PLANNING CONSULTATION RESPONSE

Application No	2026/0293
Proposal	Installation of new raised driveway access, dropped kerb and alterations to access the entrance area of dwelling.
Address	16 Tollgate Close, Shafton, Barnsley, S72 8QX
Date of Consultation Reply	18 th June 2026
Consultee	Highways DC

PROPOSED GROUND FLOOR PLAN
SCALE 1:50

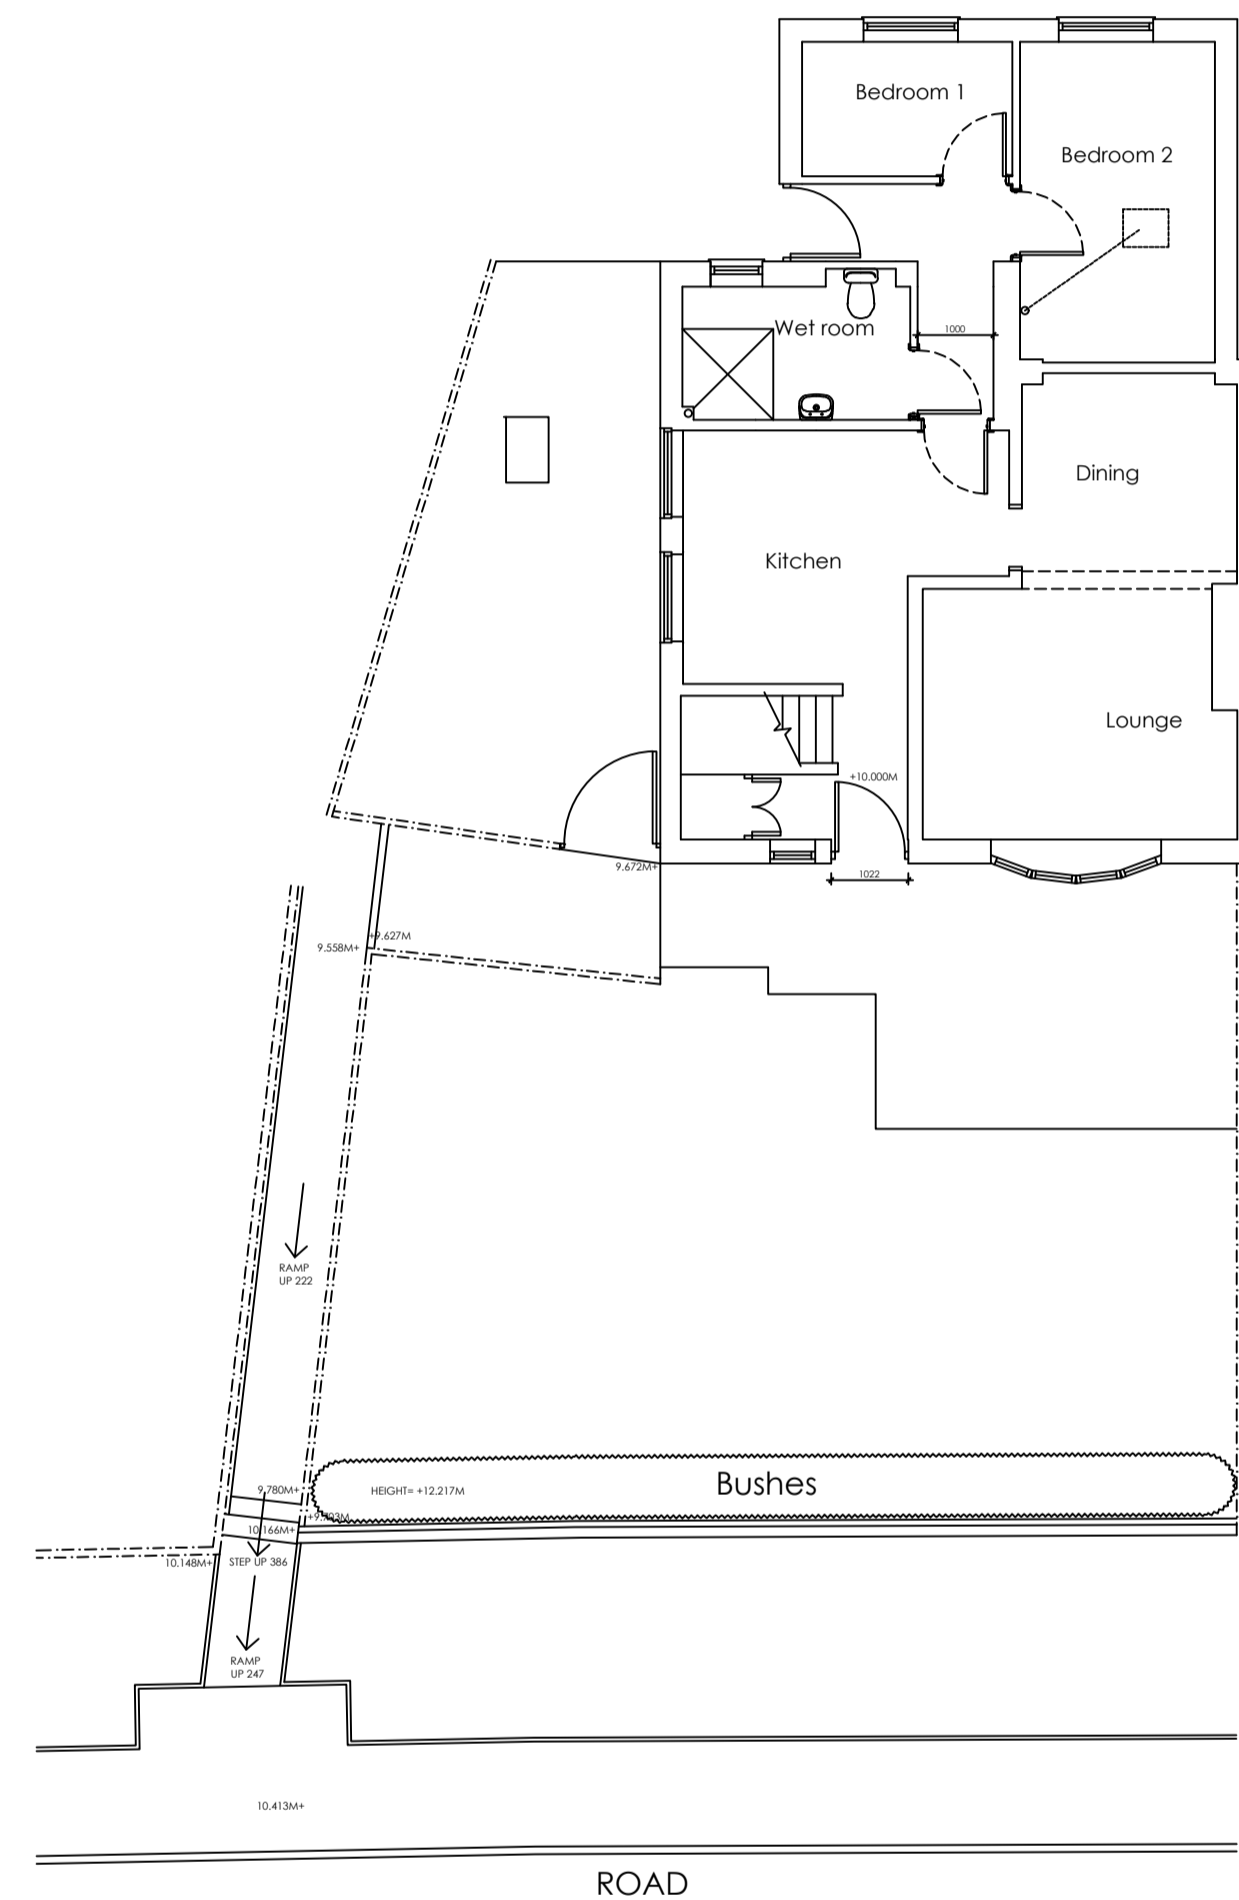
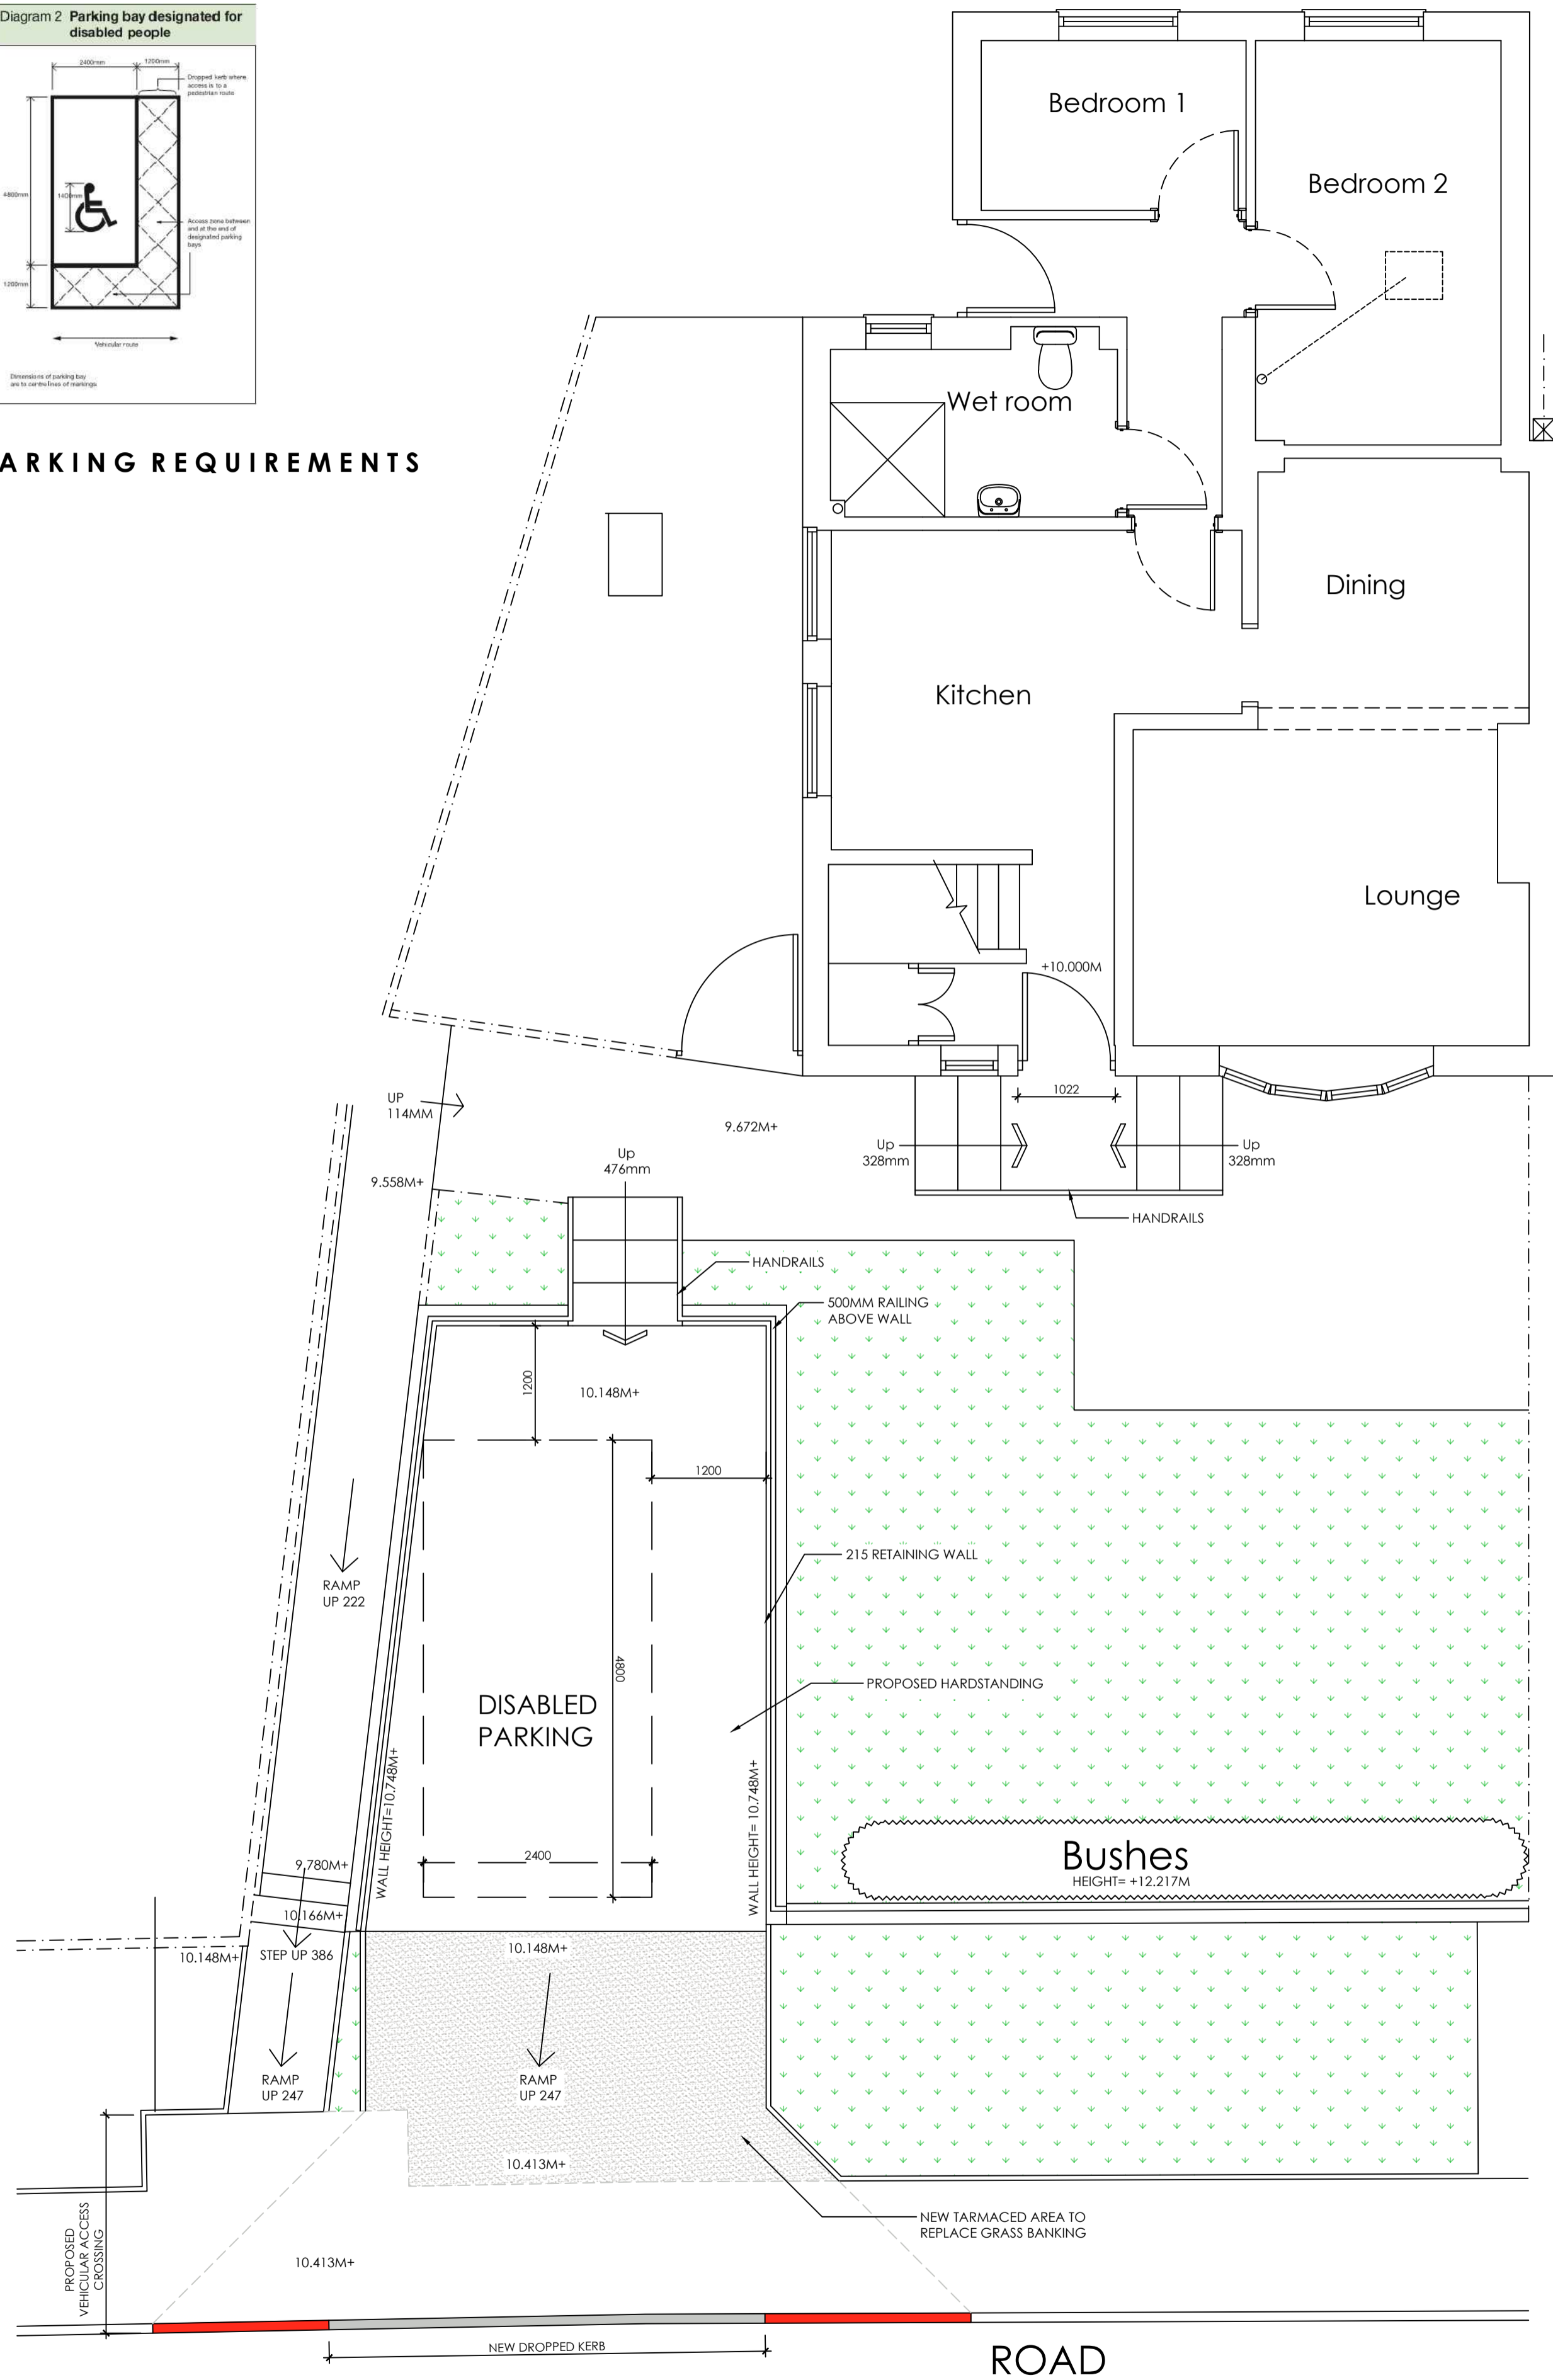
The parking space indicated on the proposed site layout plan is shown to have insufficient dimensions of 2.4m x 4.8m, however, it is evident that the required 2.5m x 5m dimensions can be accommodated within the proposed parking area.

The proposed site layout plan provides two spot levels within the ramp across the grass verge; 10.413m and 10.148m which are a distance of 2.281m apart. This would result in the access having a gradient steeper than 1:9 which is not acceptable; the access should have a maximum gradient of 1:12. The distance between the actual back of the footway (which also has a level of 10.413m) and the 10.148m spot level is 2.475m or 2475mm. Over this distance, in order to achieve a gradient of 1:12, the access can fall a maximum of 206mm. The level would therefore need to be raised from 10.148m to 10.207m. $[10.413\text{m} - 0.206\text{m} (206\text{mm}) = 10.207\text{m}]$ $[2475\text{mm distance} \div 206\text{mm fall} = 12.01$ which equates to a gradient of 1:12.]
